Fire Marshal Division

Re: Coble Ski School Buildings Up-fit

Application Number FMFW 1810-0010

PARTIAL SITE PLAN - BUILDINGS & SPRINKLER PROTECTION SITE PLAN

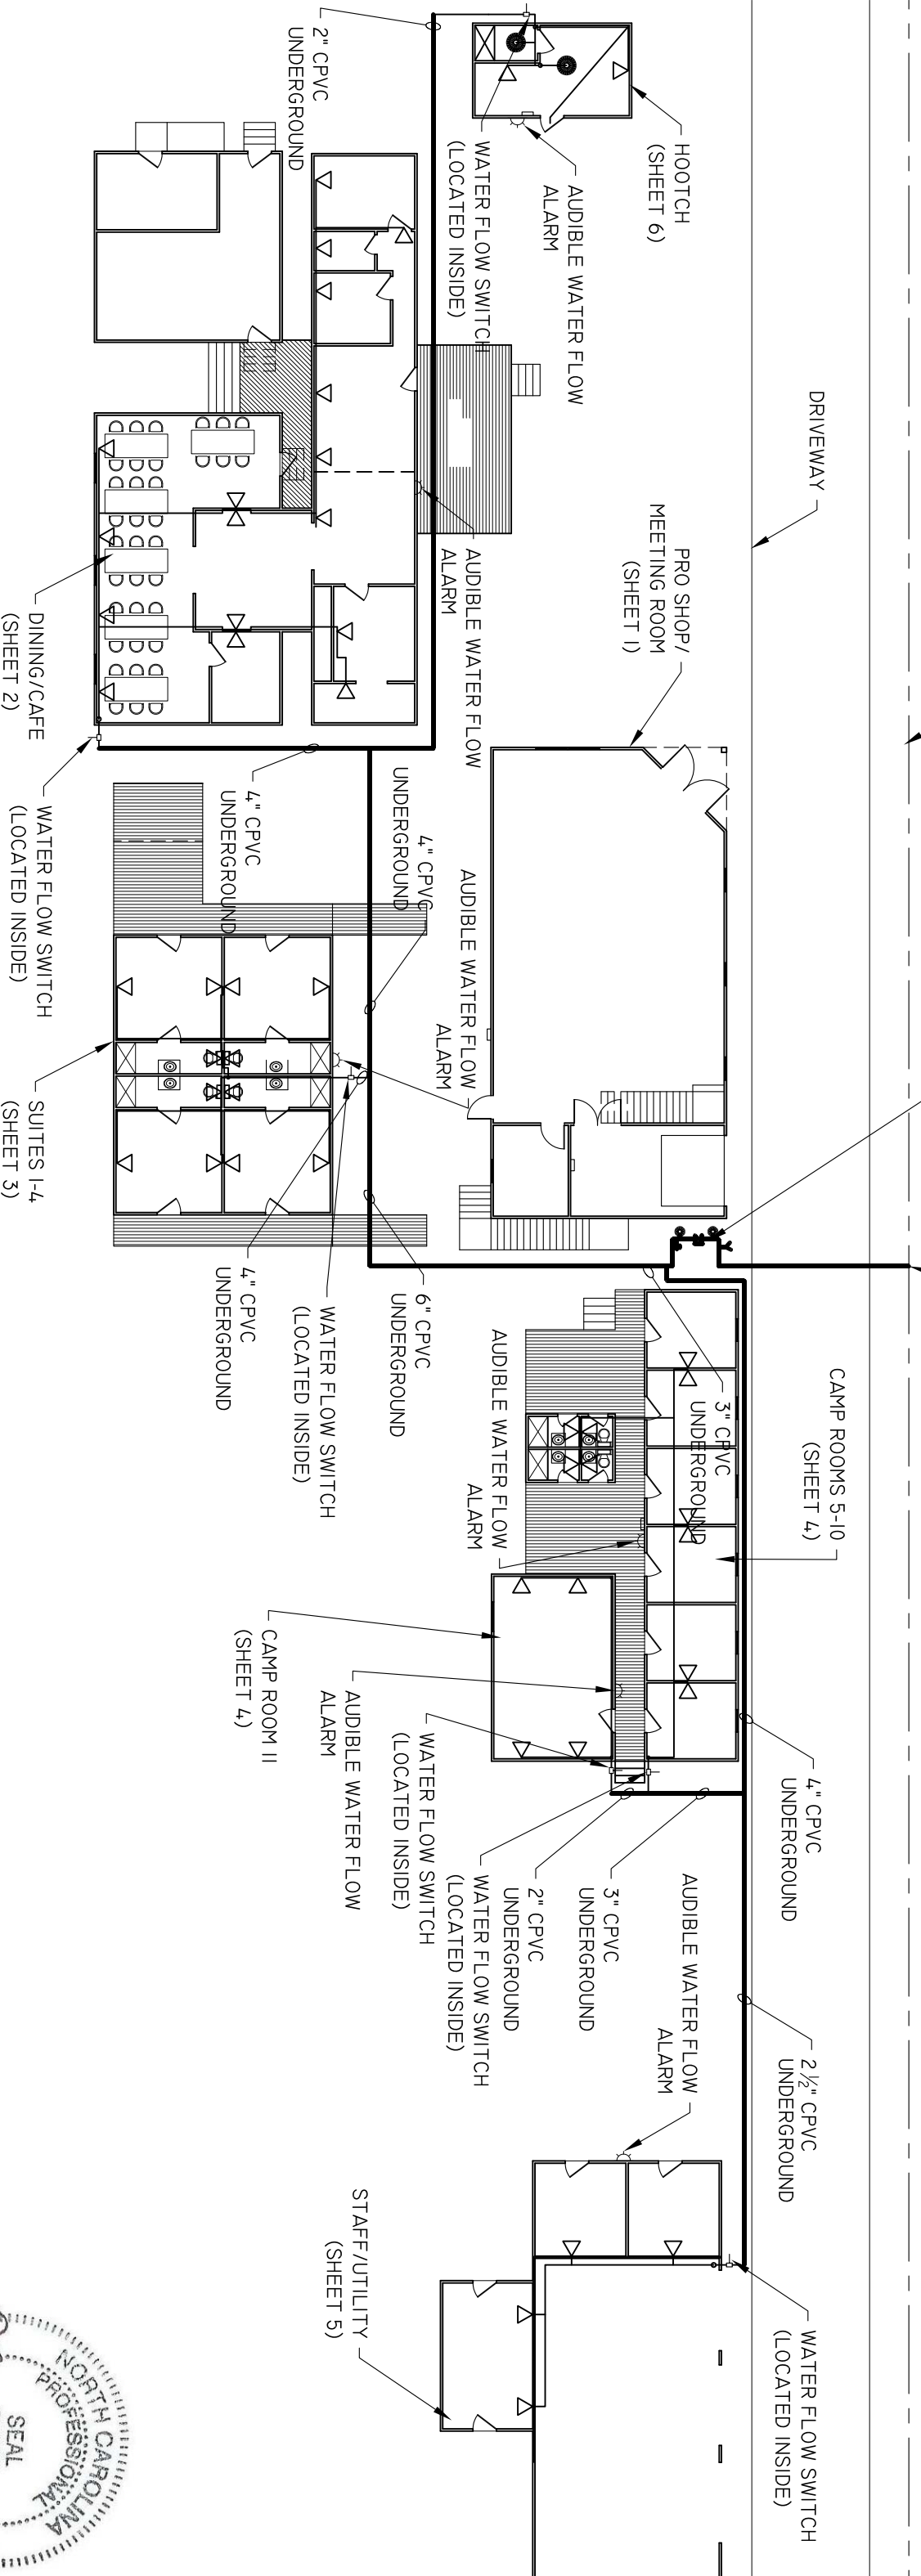
- **105.7.1 Automatic fire-extinguishing systems.**
 - A construction permit is required for the fire sprinkler system installation before any such work commences. Submit complete construction documents that include the hydraulic calculations for the system. The system shall also be designed consistent with the architectural design documents and specifications. Construction documents shall include detail as described in NFPA 13D standard for automatic sprinkler system installation. Contractor must obtain construction permit for the fire sprinkler system before commencement of any work.

- **507.3 Fire Flow (NFF)**
 - Provide a fire flow analysis for the building(s) and determined by an approved method. NC Fire Code Appendix B is acceptable method.

SUITES

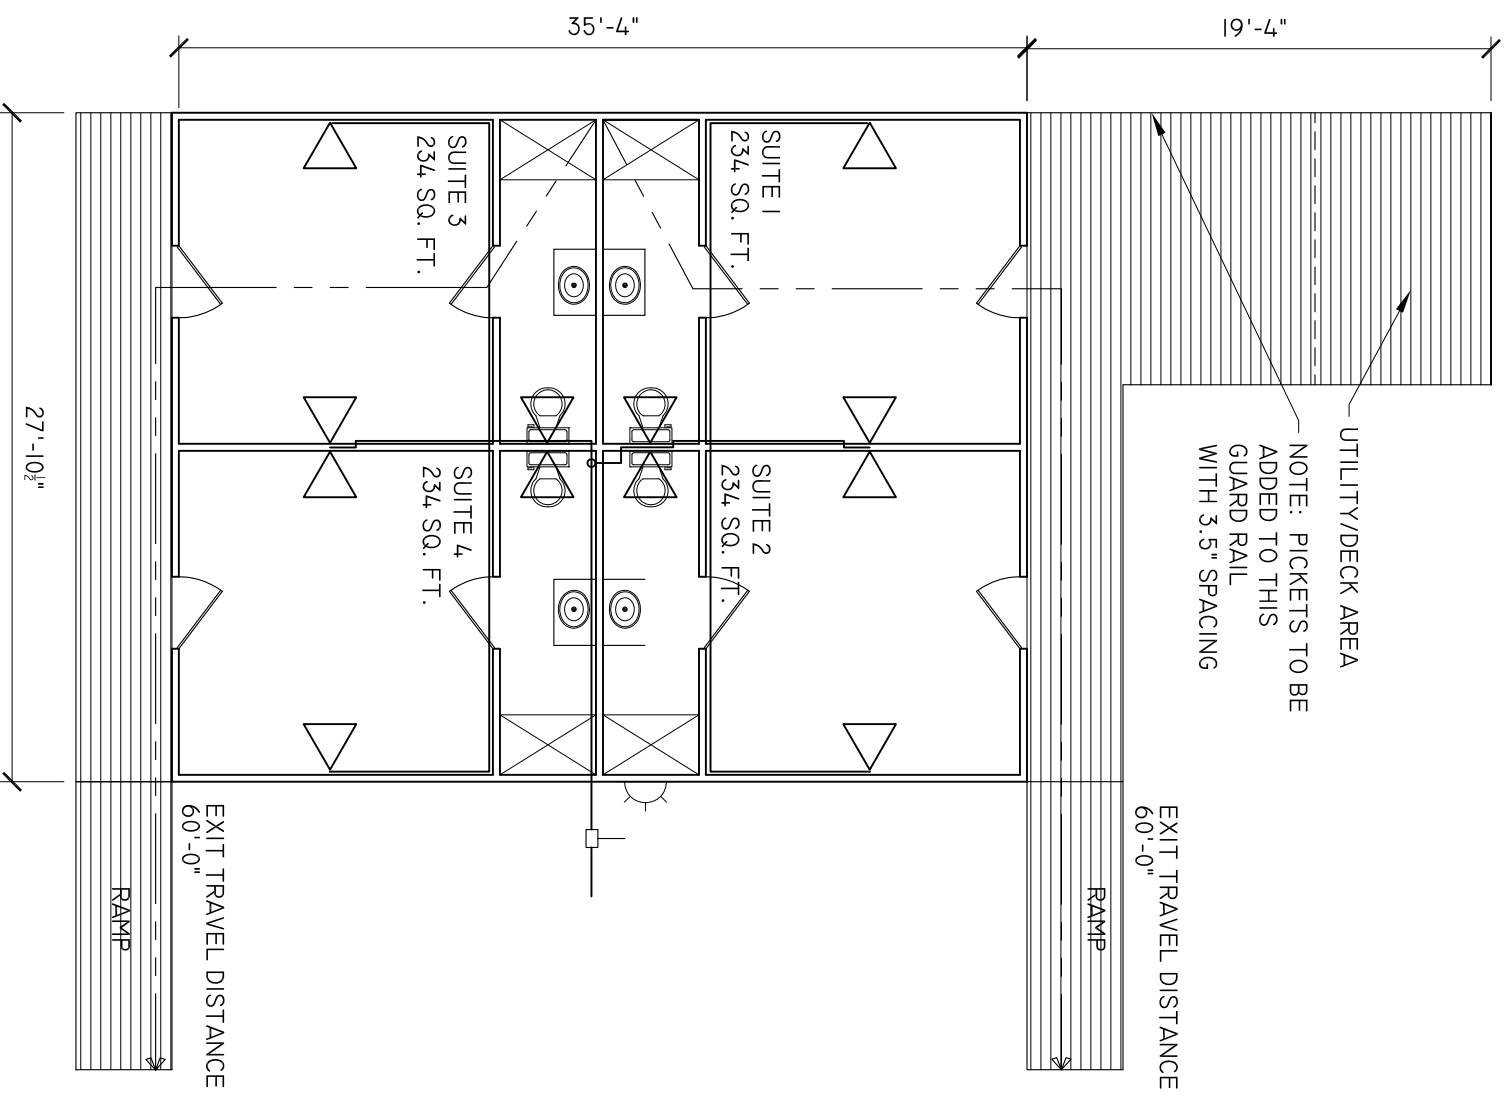
- **1004.2 Increased Occupant Load.**
 - The referenced highlighted and noted areas on the plans indicate occupant loads that exceed code requirements. The intent of the referenced plan note attempting to allow an increased occupant load is addressed by 2012 Code Commentary with the intent of addressing standing room events. This does not correspond to the intent of sleeping quarters as submitted. Consider the dormitory definition as it may apply to the proposed use.
